**KIRKLEES METROPOLITAN COUNCIL
INVESTMENT & REGENERATION SERVICE**

Reference No: 2019/62/93520/E

Site Address: 25, Barnsley Road, Flockton, Huddersfield, WF4 4DW

Description: Demolition of existing stables/greenhouse, erection of stable block and formation of manege and hardstanding

DRAWING STABLES ELEVATIONS.	NUMBER 3188/5
--------------------------------	------------------

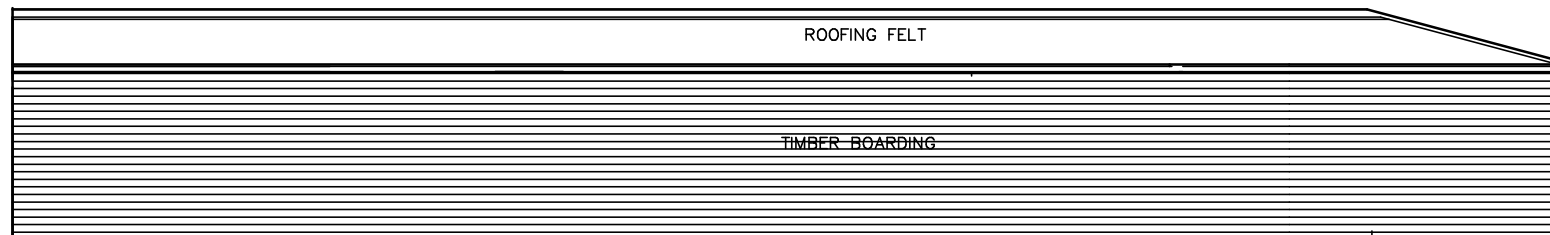
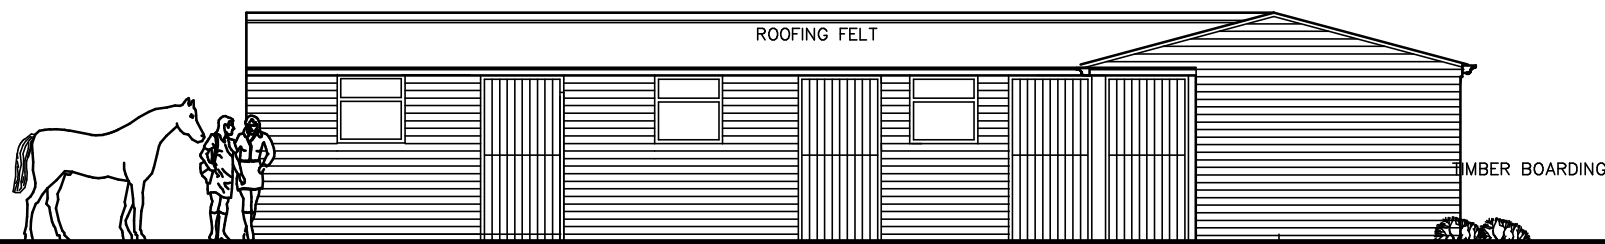
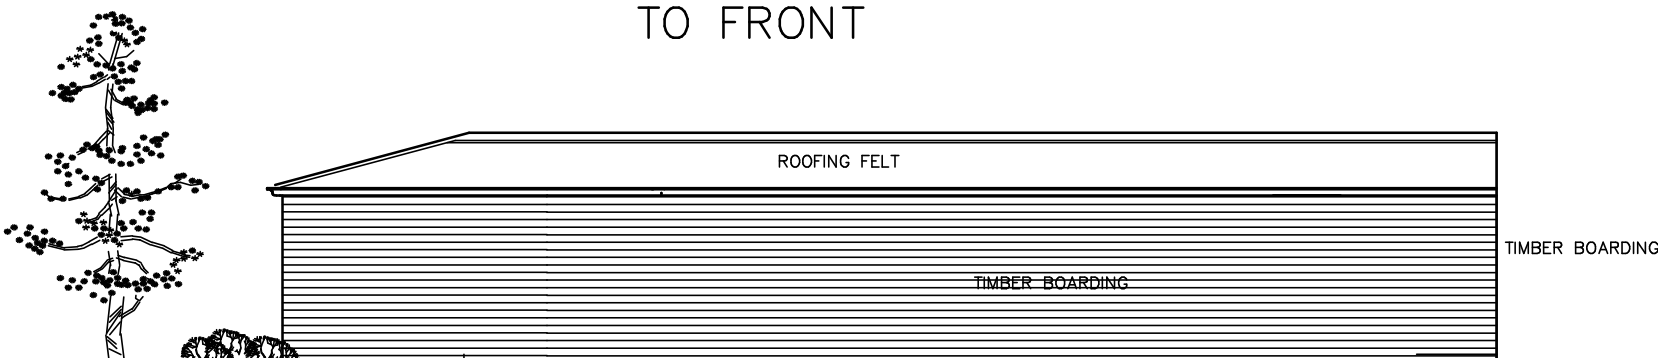
The proposed stable block would be of an acceptable appearance, having an L-shaped layout and located within the north east corner of the existing hardstanding to the rear of the dwelling. This would replace an existing smaller stable block and greenhouse. As a result of the siting and

appearance of the proposed stable block, this aspect of the proposals is considered to be unobtrusive. The submitted plans do indicate the inclusion of a relatively large area of block paving, which, it is considered would introduce an urban element. Whilst a small concrete apron around the stables would be acceptable, beyond this it is considered that a surfacing material of a less permanent construction and appearance (for example crushed stone) would be more appropriate in this instance. This could be controlled by condition.
